In reference to The New Forest High School (SSD-26876801).

Ausgrid would like to thank you for seeking input and feedback regarding the Environmental Impact Statement (EIS). Ausgrid has undertaken a review of the EIS and associated information in relation to potential impacts or interfaces with Ausgrid's electricity infrastructure.

project: THE FOREST HIGH SCHOOL
 drawing: FENCING LOCATION PLAN
 checked: SW scale: 1 : 500@A1
 drawn: AD KG JL IT SL SW project no: 200420.01
 drawing no: **SSDA-9301** issue: **C**
 31/10/2022 5:19:29 PM

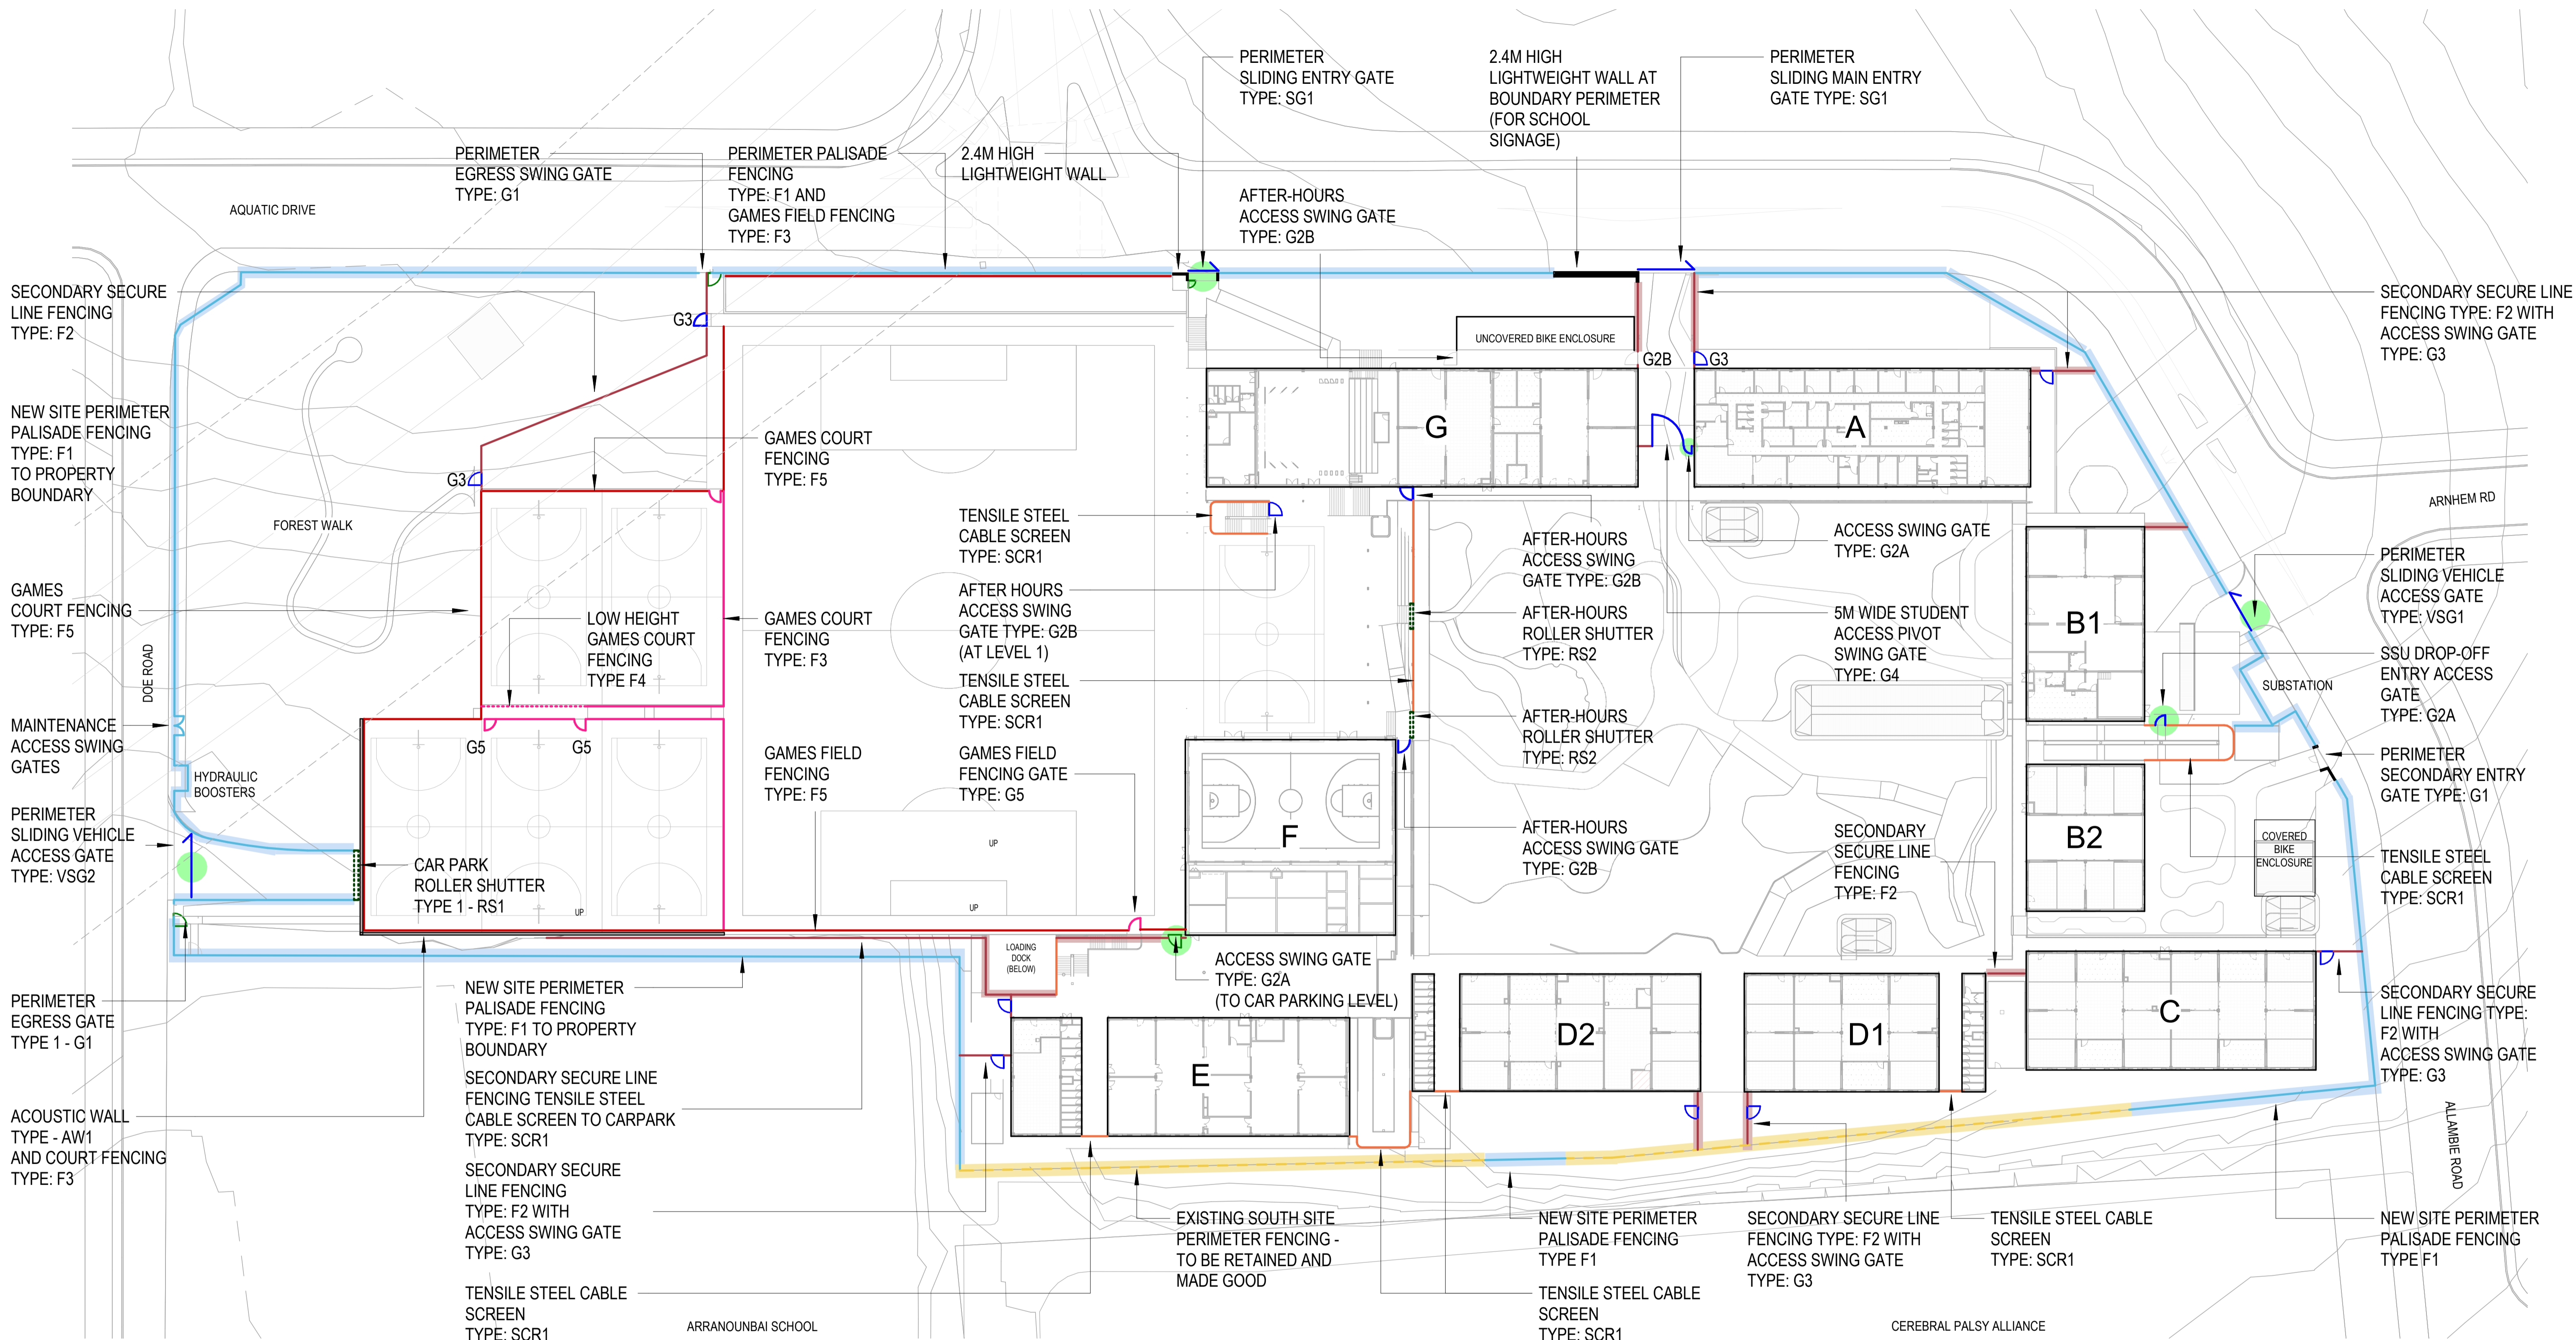
9. All metal work within the easement site including metallic fencing, are to be locally earthed by a qualified electrician via a 50 sq. mm stranded copper, insulated earthwire bonded to a copper-clad earth stake driven at least 1.6 metres into the ground.

10. Metallic fencing is generally not permitted to extend away from the easement site unless an insulating section is installed, at least 3 metres wide. This requirement maybe relaxed upon assessment of a supplied fencing design.
